DEVELOPMENT REVIEW BOARD
TRANSPORTATION DEVELOPMENT

DRB Project Number: 2019-002380
Mercado El Milagro

SUBJECT: Site Plan-DRB

SHEET NO:
A1.2
2 OF 14

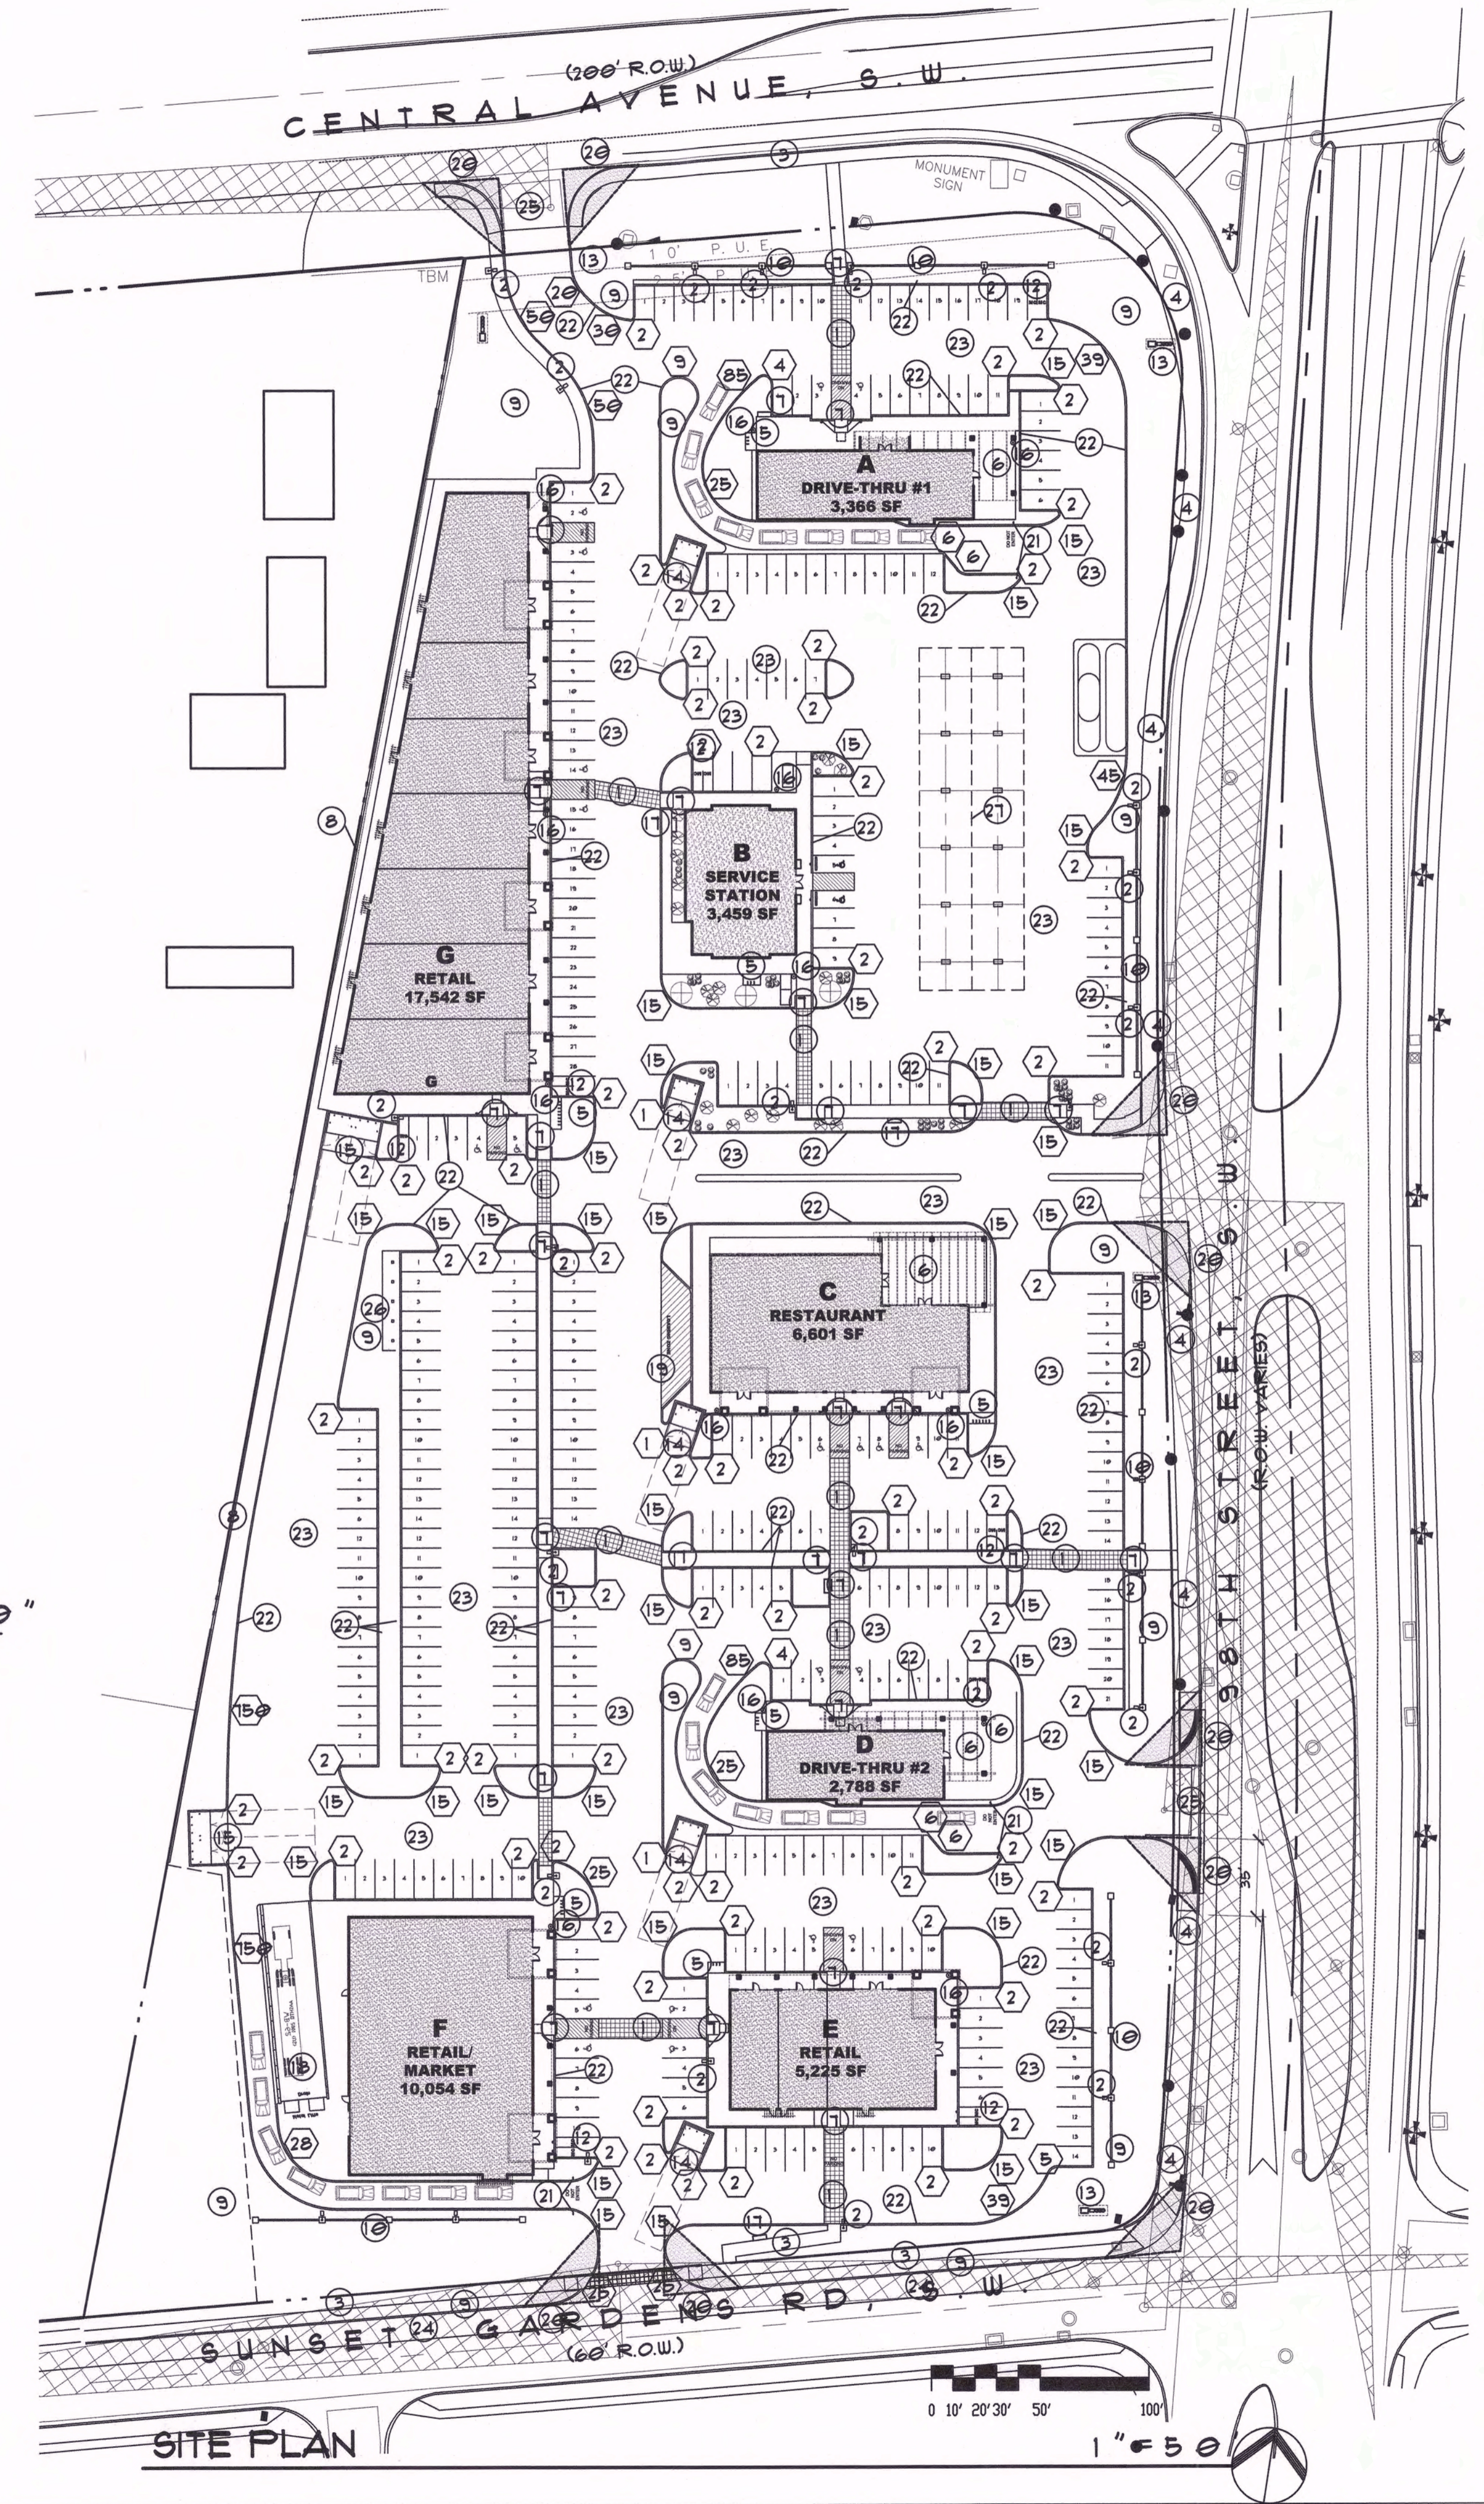
1. One-way vehicular paths on-site require pavement directional signage, and a posted **“Do Not Enter”** sign at the point of egress for Building F. **See revised sheets A1.2 & A2.6**

5. On enlarged plan, Building F shows a one-way access width of 10’-2” when the minimum required width for one-way access is 12’. **See revised sheet A2.6, A1.1, A1.2 for widened drive aisle**

9. Label the existing trail and power poles along 98th Street and the new sidewalk, curb, and gutter, and proposed additional pavement width on the site plan to match the infrastructure list. Provide dimensioning of all new infrastructure within COA Right-of-Way. All of these items have to be shown within City right-of-way. Right-of-way dedication may be required. **See revised sheets A1.1, A1.2**

SHEET NO:
A1.3
 3 OF 14

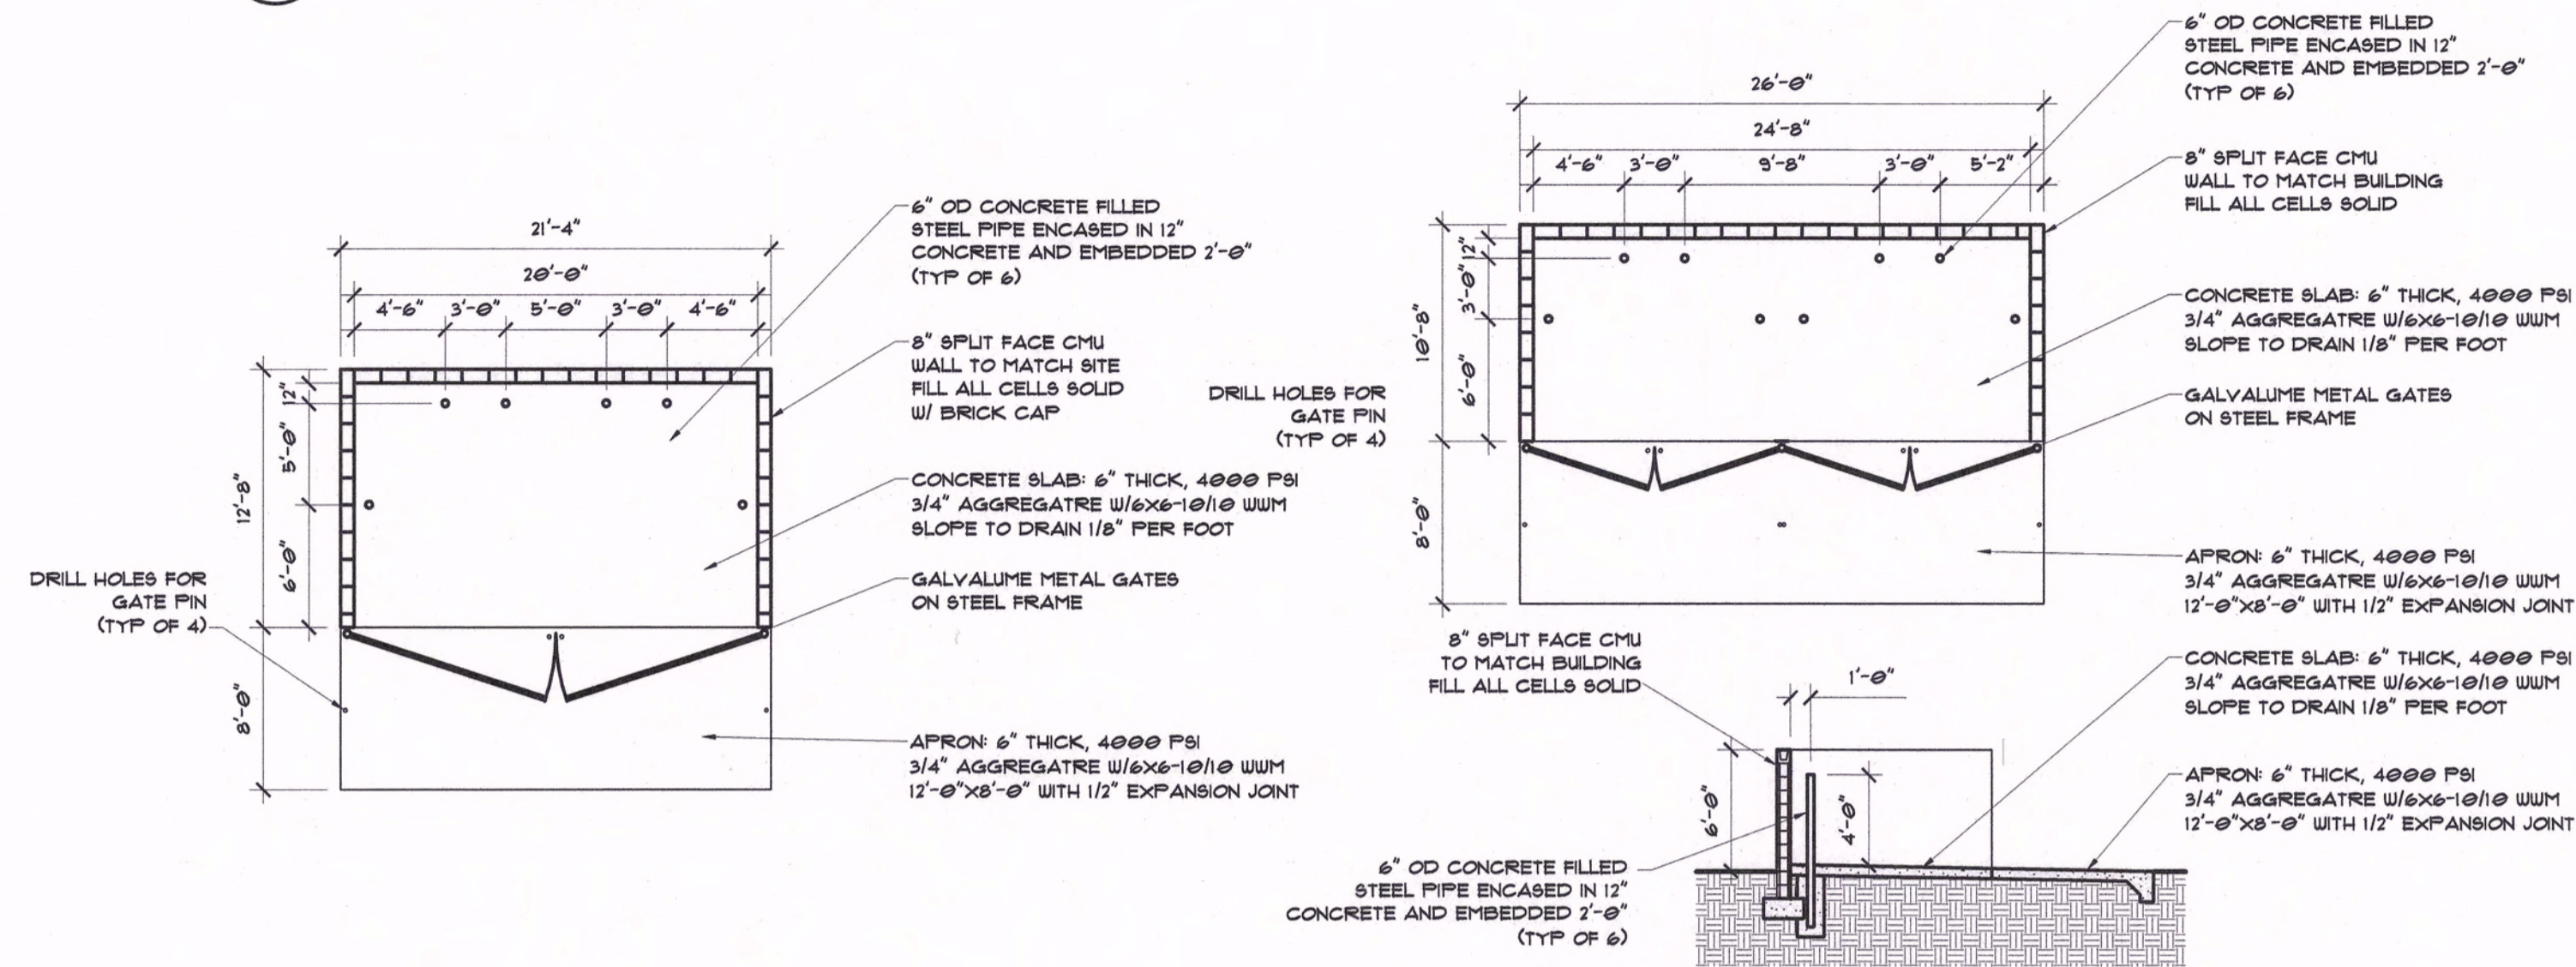
2. Provide a 6” curb detail and internal sidewalk details. Show that the maximum sidewalk cross-slope is 2%. **See revised sheet A1.3, details 10, 11, and 12**

3. Specify height of lettering for “No Parking” lettering on pavement for van accessible aisles. The letter letters shall be in capital letters, each of which shall be at least one foot high and at least two inches wide, placed at the rear of the parking space so as to be close to where an adjacent vehicle’s rear tire would be placed. (66-1-4.1.B NMSA 1978)
See revised sheet A1.3, Detail 7a
